Our Ref: P/84/21/DOC

Approval of details reserved by condition imposed under ref W/4001476 (P/58/19/PL) relating to Condition Nos 5 - Construction & Environmental Management Plan, 6 - surface water drainage, 7 - maintenance & management of surface water drainage, 8 - badger survey and 9 level survey.

253-255 Pagham Road Pagham PO21 3QB

Arun District Council have decided to **REFUSE details reserved by condition for the following reasons:**
Council Drainage Engineers have raised concerns with the drainage scheme as submitted and are not able to recommend discharge. The matters which currently need resolving are explained in the drainage advice dated 20/07/21 and relate to:

Drawing Status	FOR APPROVAL						
Client	Future Group Development Ltd						
Project	Land at The Inglenook Pagham Road, Bognor Regis PO21 3QB						
Drawing Title	Proposed Drainage Arrangement Sheet 2 of 2						
Scale	1:200	Date	May 2021	Drawn By	DJL	Checked By	MJA
Drawing No.	D1966-103.2	Rev.	-

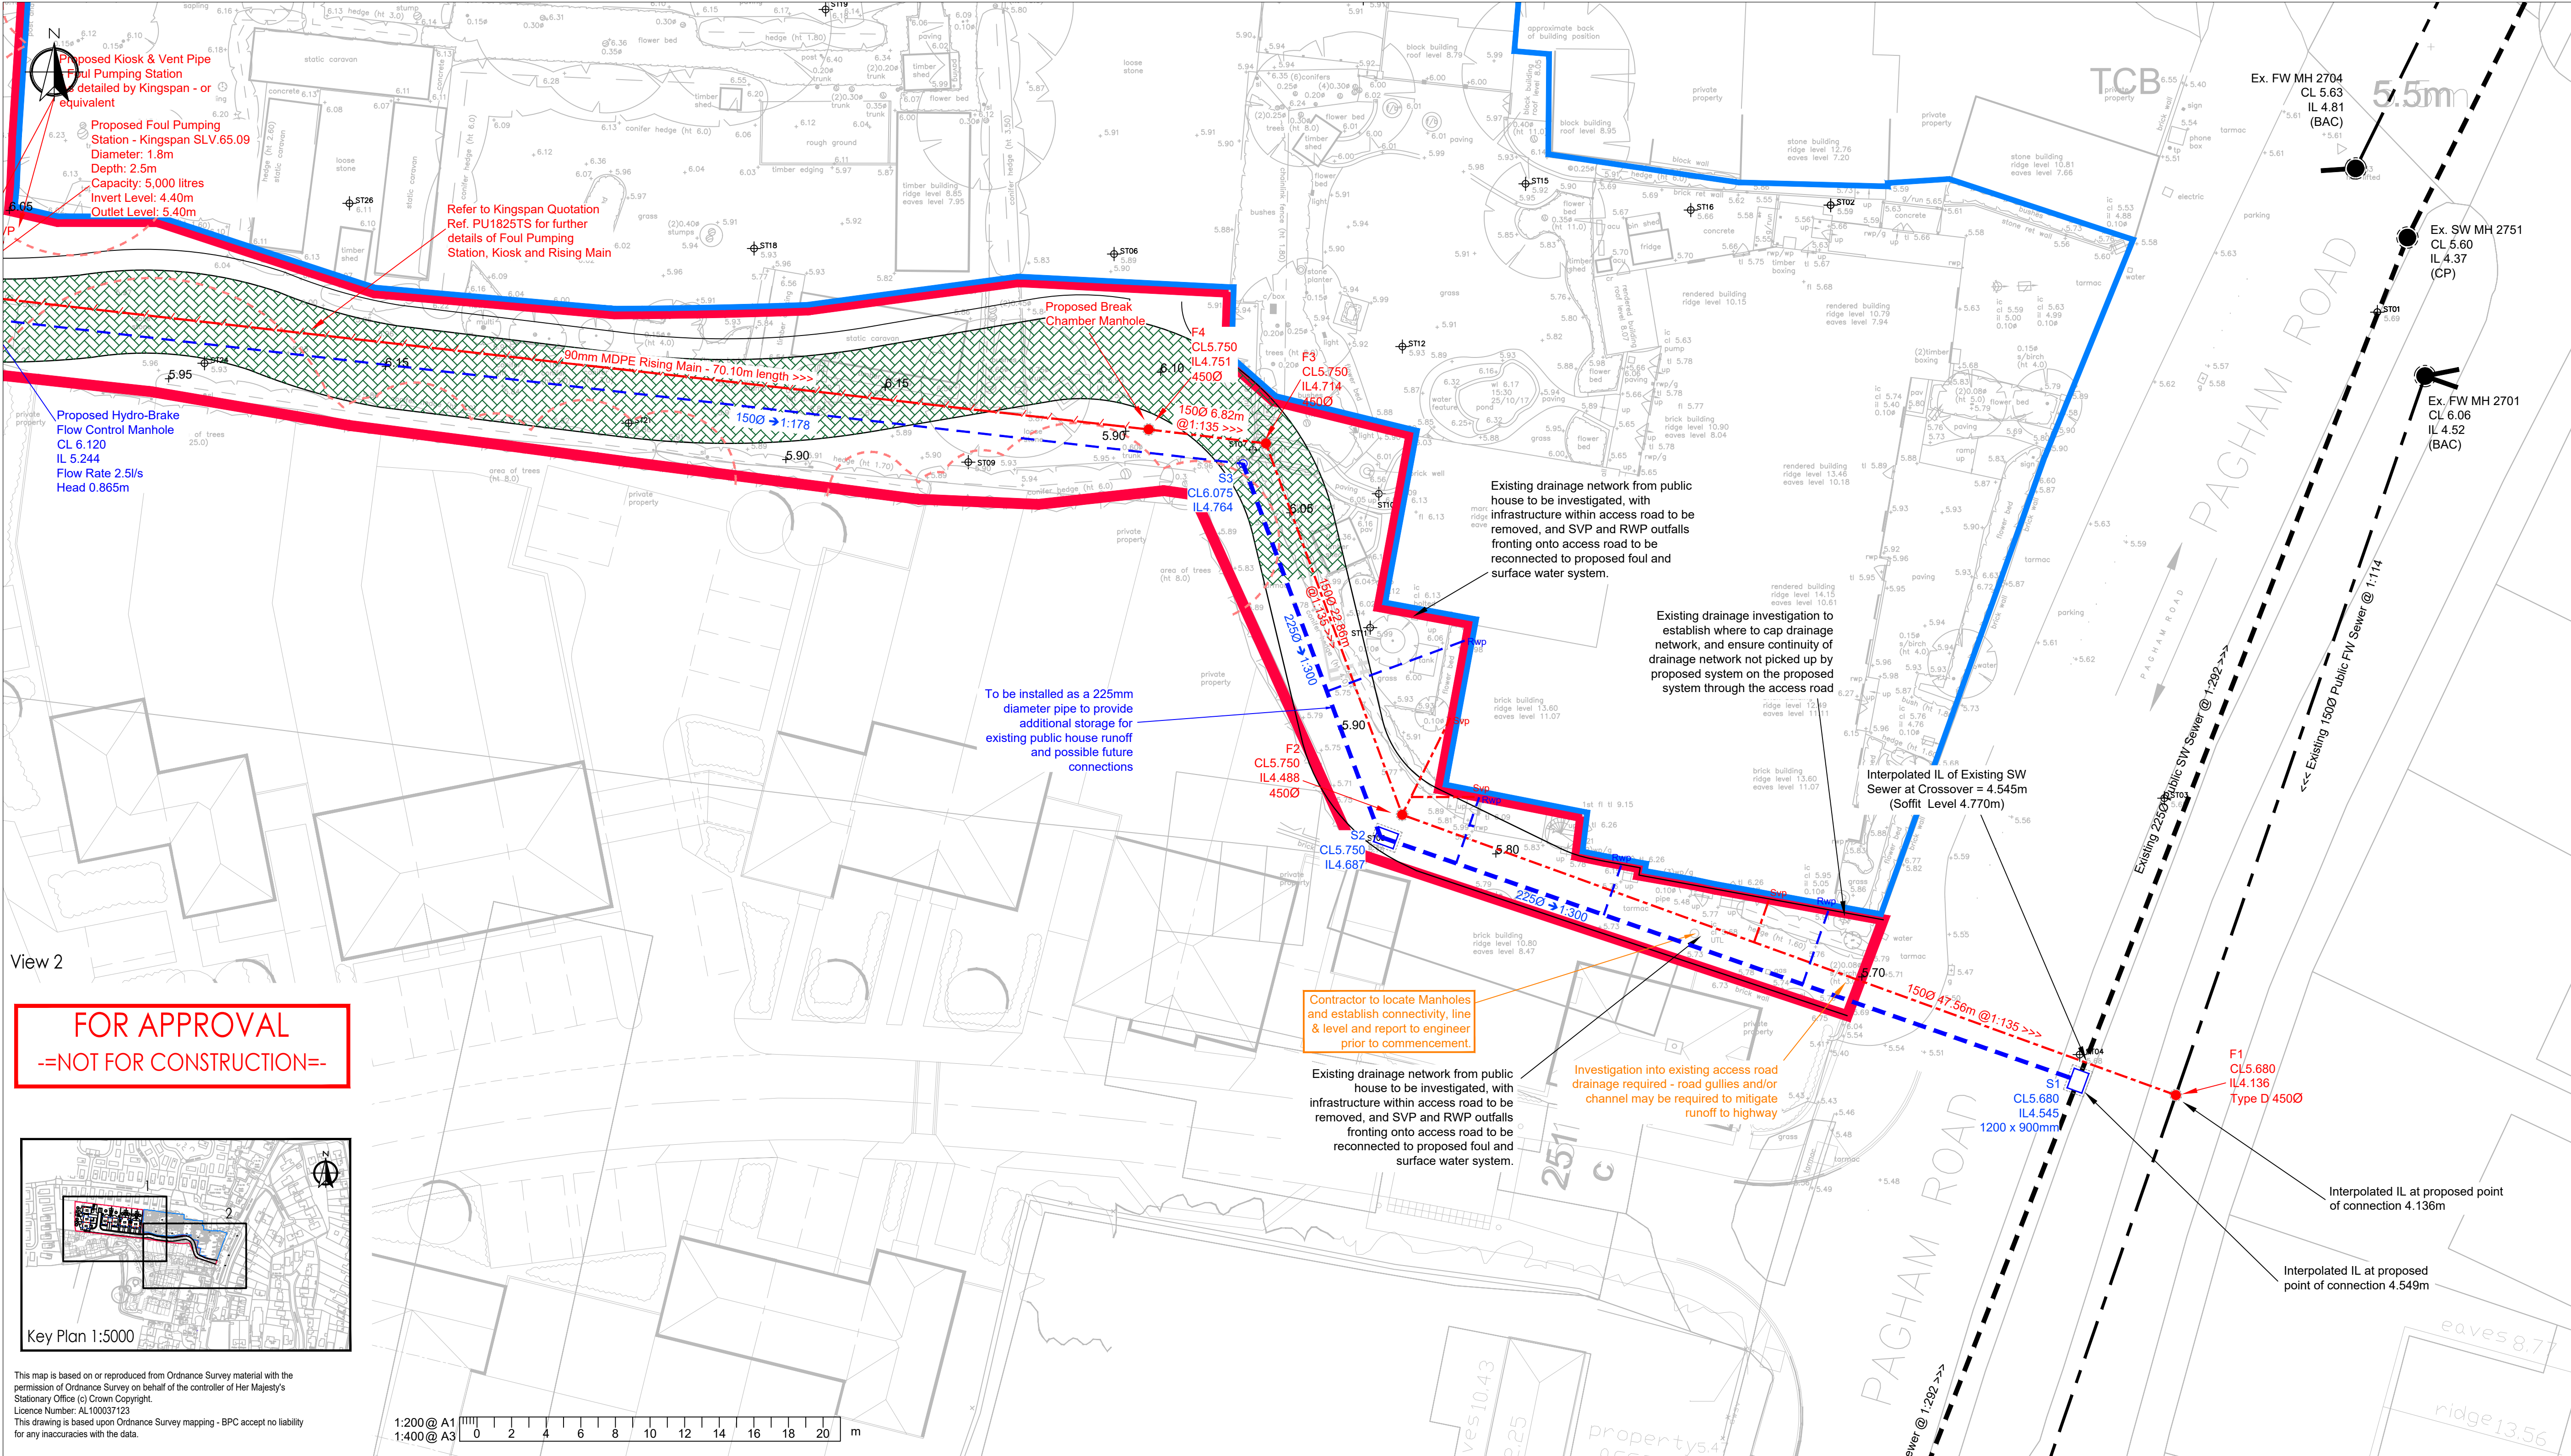
- Formation levels and diffuser inverts;
- Hydrobrake reference;
- Bypass door; and
- Southern Water s106 Technical Approval.
